2506 Innes Road

Response to Deficiencies
Site Plan Control Application
October 23, 2024

2506 Innes Road - Site Plan Control Application

RE: Consolidated Response to Deficiency Review Comments
2506 Innes Road - Site Plan Control Application

Drawn
D.B.G.
H. Scale
1:200
V. Scale
Date
Dec 20-23
Job No.
23087

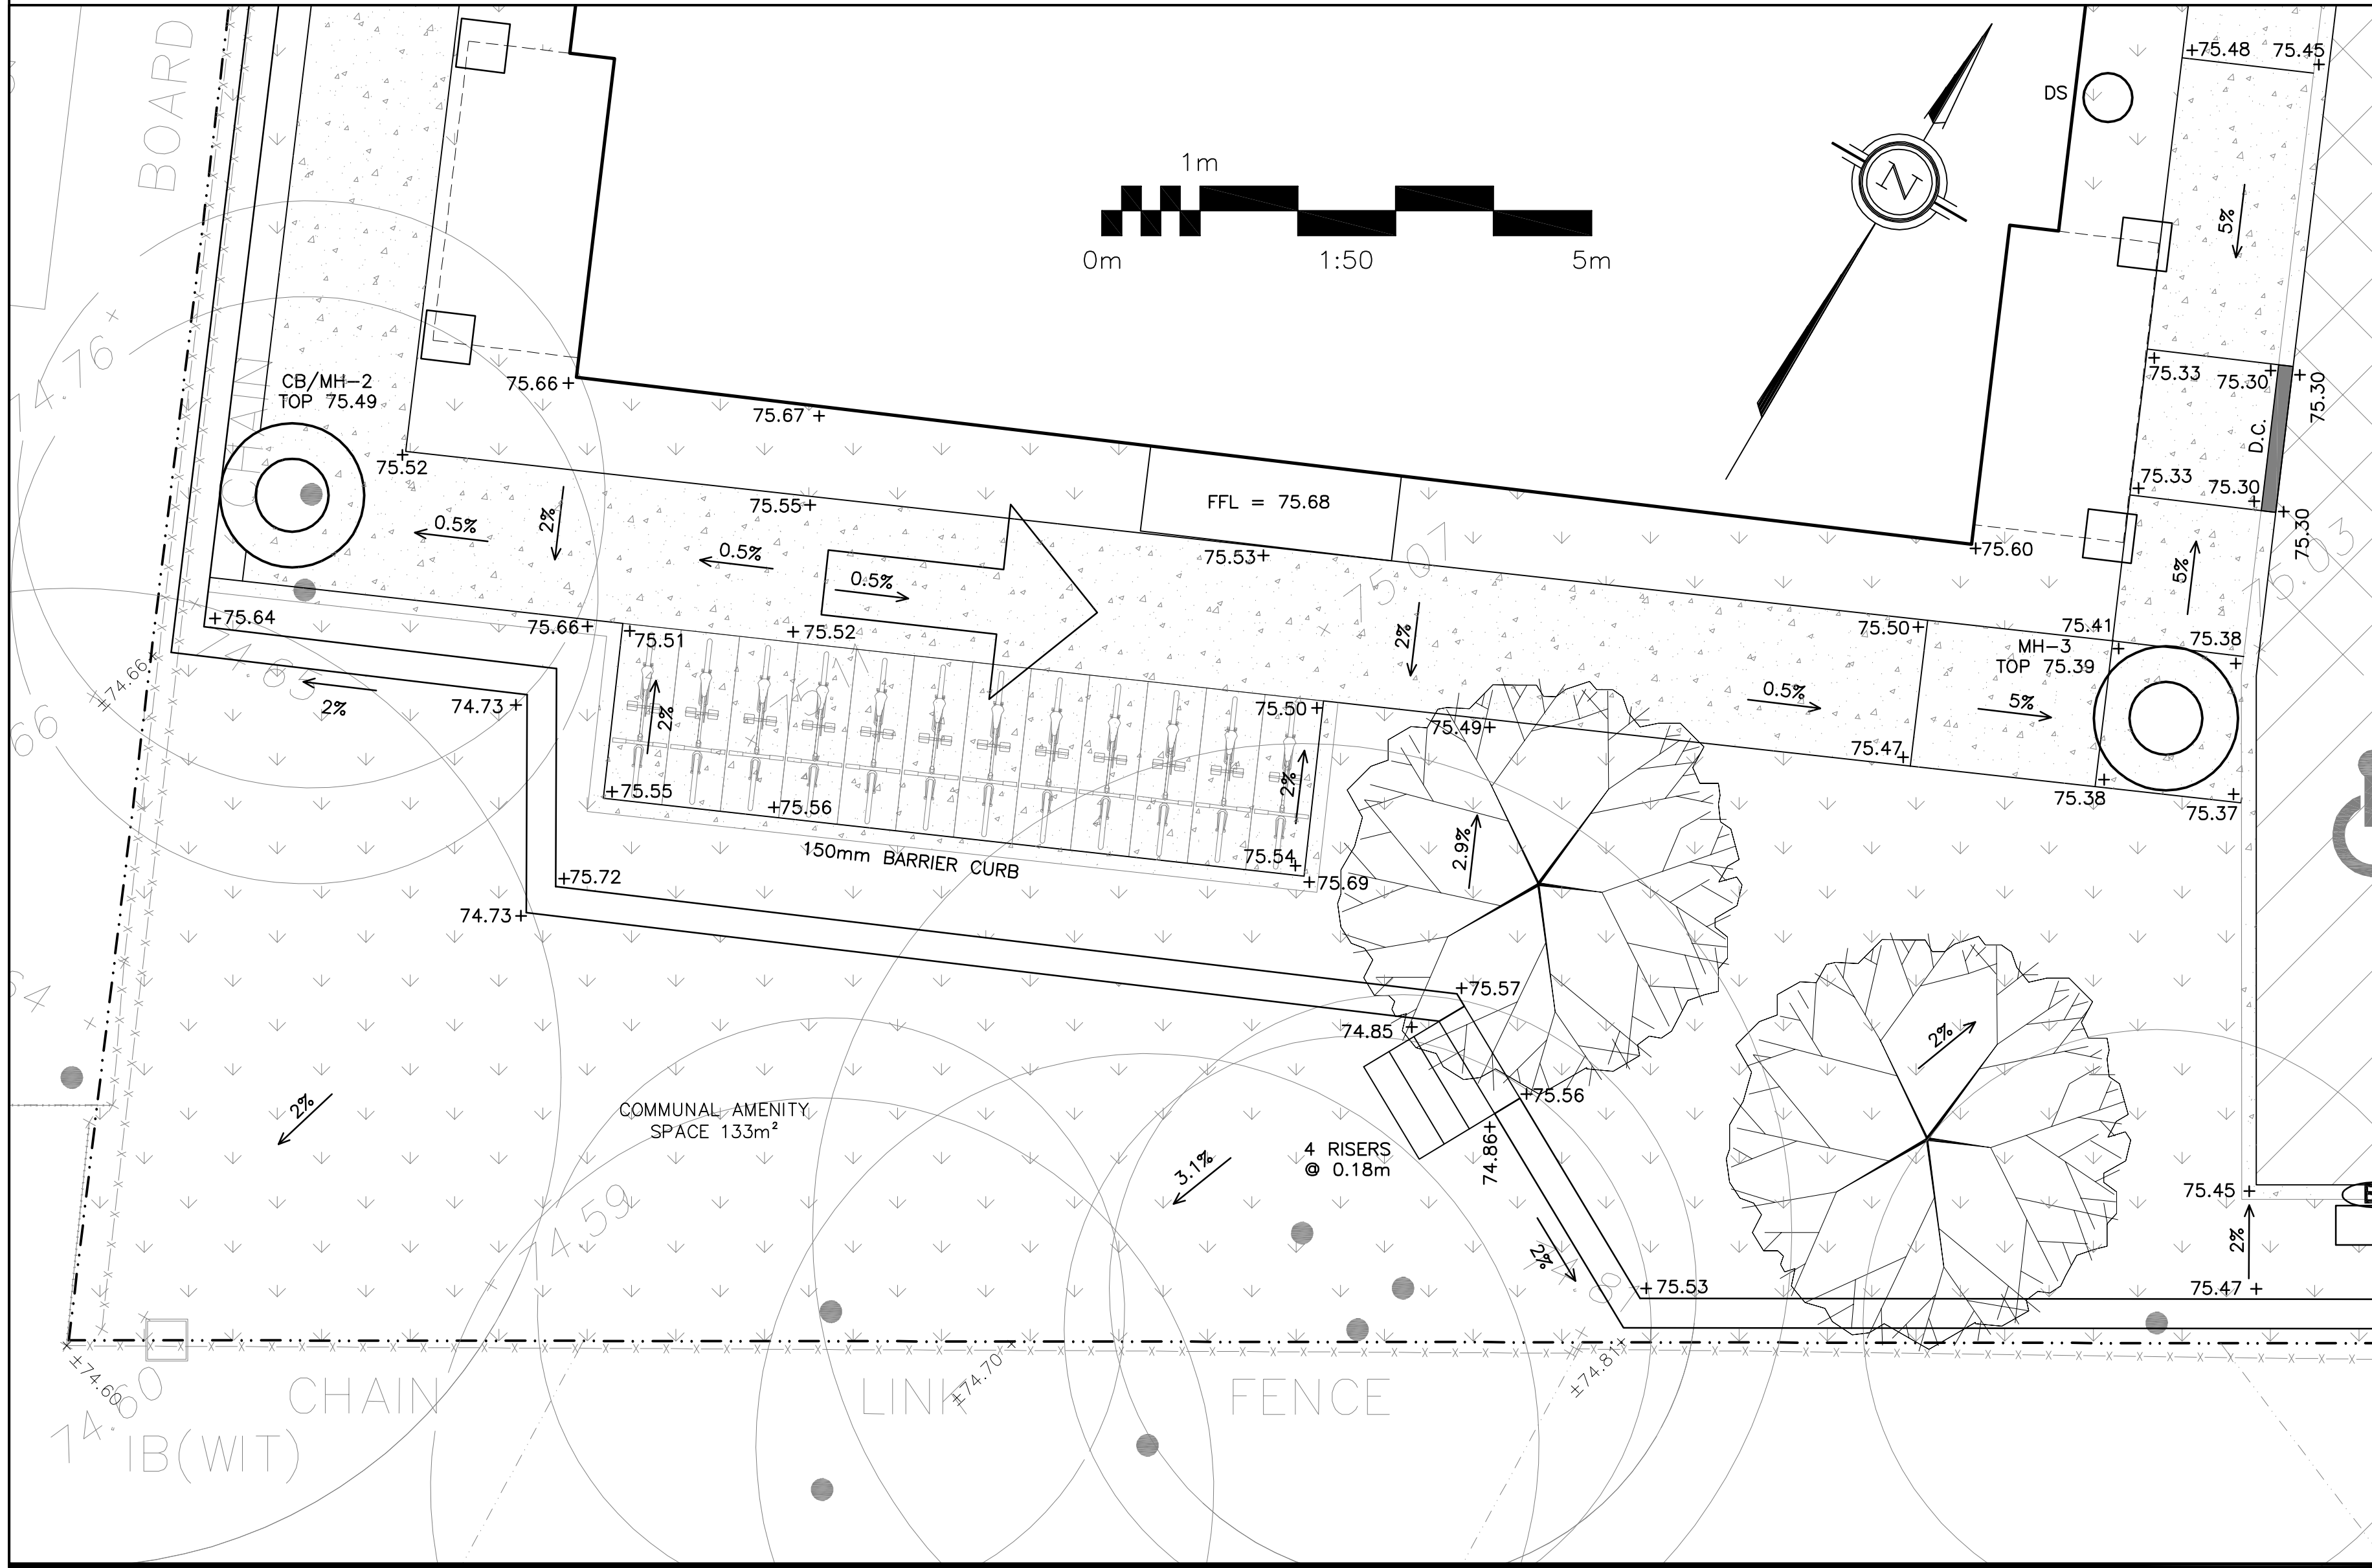
Comments:	Response
Engineering	
Grading Plan	
Deficiency #1	See the revised Grading Plan in submission package now including five metres of topographic details outside of the property line.
Deficiency #2	Grading Plan updated to address these concerns. Amenity Area is now more easily accessible.
Phase 2 Environmental Site Assessment	
Deficiency #3	See Phase 2 Environmental Site Assessment is re-submitted submission package.
Site Servicing and Stormwater Management Report	
Deficiency #4	Floor areas in the FUS calculations now match that in the Architecture plans. To be conservative the ground and second floor balconies were included in the FUS calculations.
Pre-Development and Post-Development Drainage Plans	
Deficiency #5	There appears to be an existing curb along the east property line preventing the neighbouring property from draining onto the subject property. The 1.5 m landscape buffer sheet flowing ± 0.7 L/s (± 20 mL/m) during the 100-year event over the retaining wall should not be viewed as a waterfall or safety concern.
